State Significant Development - Moriah College Redevelopment – Amendments

Addendum to the CPMPT Submission (dated 17 December 2019)

The Centennial Park and Moore Park Trust is the owner of Lot 23 / DP879582 (York Rd Bushland) and Lot 1724 / DP45644 (Queens Park) adjacent to the Moriah College Redevelopment area (Application Number SSD-10352).

Figure 5. Vegetation communities of the subject land

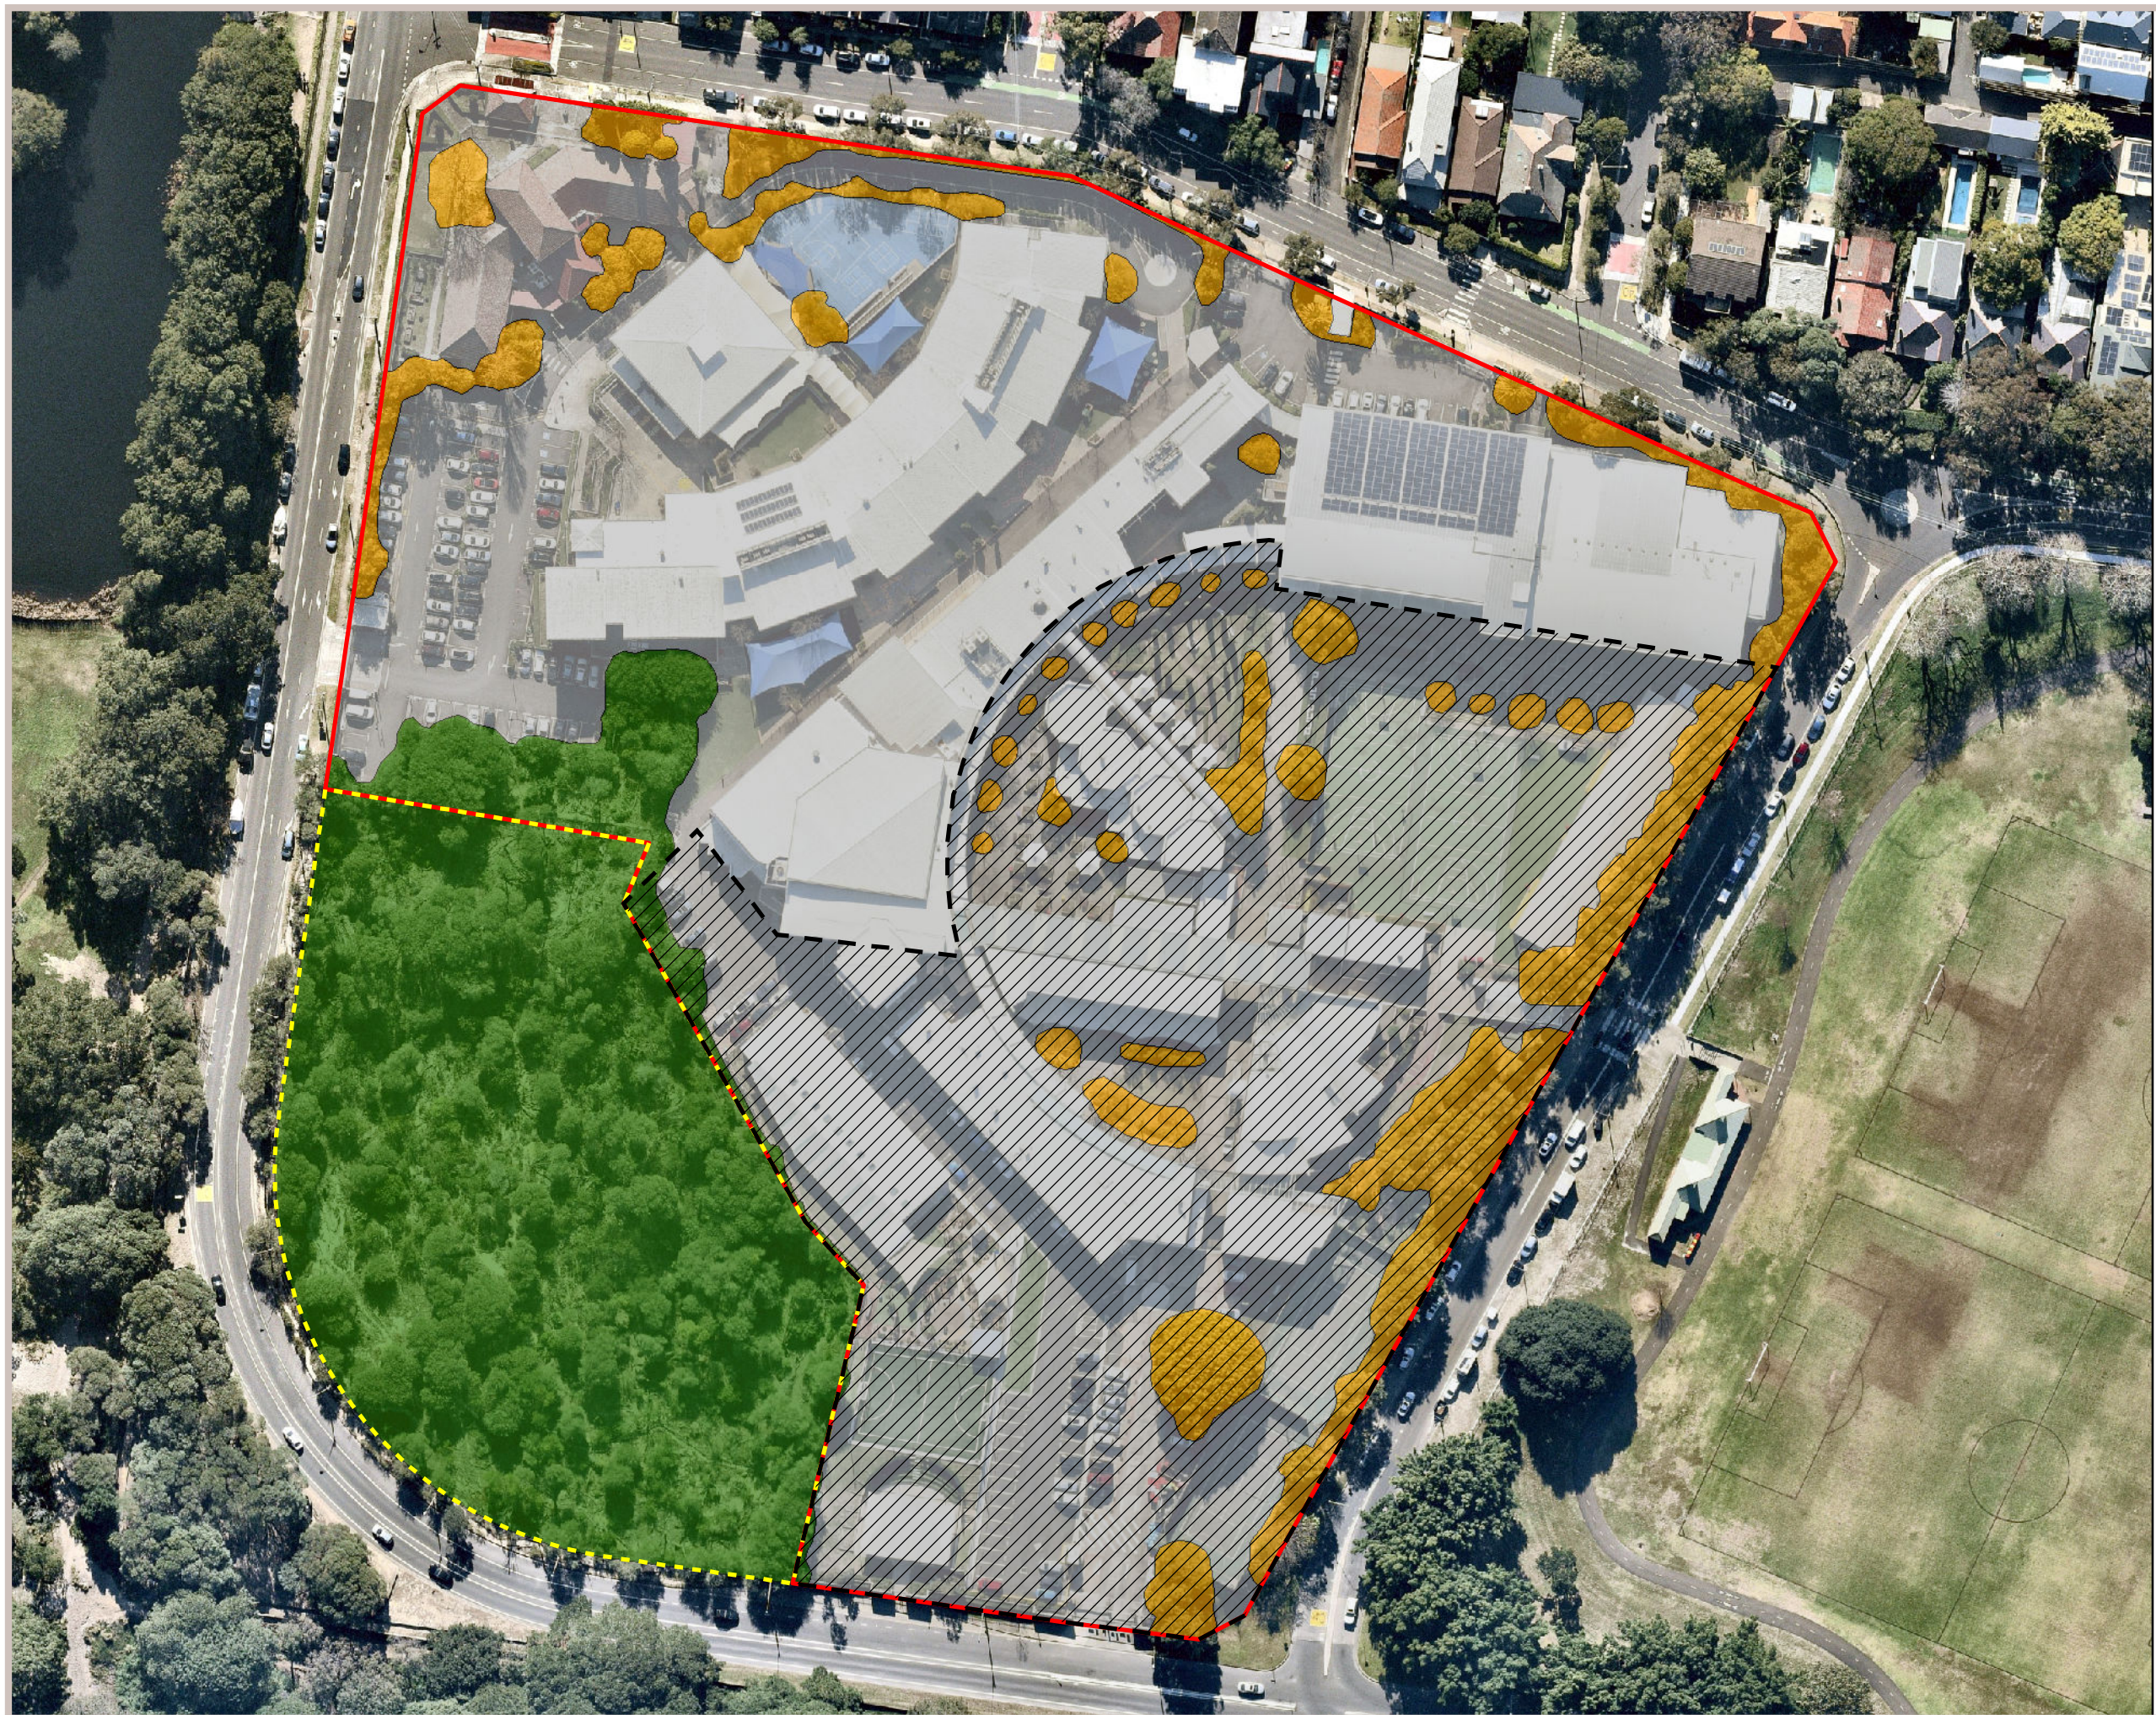
An updated Moriah College Vegetation Management Plan (as Appendix K to the Response to Submissions SSD 10352) has been prepared with particular reference to areas immediately adjoining the development site (Lot 23 DP879582 and the connected vegetation in the southern portion of Lot 1 701512). The Moriah College VMP does not mention the Centennial Park and Moore Park Trust as the owner of Lot 23 DP879582 (See Map below, Attachment A).

The VMP suggests that 3 monitoring plots (See Attachment B) will be established within the ESBS remnant owned and managed by the Trust, with none in the ESBS area managed by Moriah College.

The Trust have our own VMP in place (WSP, 2018), and our approach predominately uses natural regeneration techniques. The proposed planting plan by Moriah College (Cumberland Ecology, 2020) is not consistent with our management plans. The location and quantity of proposed planting of trees and shrubs is not approved within the ESBS owned by the Trust.

The CPMPT request that the VMP make clear the boundaries of different landowners. If Moriah College are required to improve the current condition of the ESBS in Lot 23 DP879582 as part of the DA approval, then the CPMPT would wish to oversee these works and a memorandum of understanding would be required.
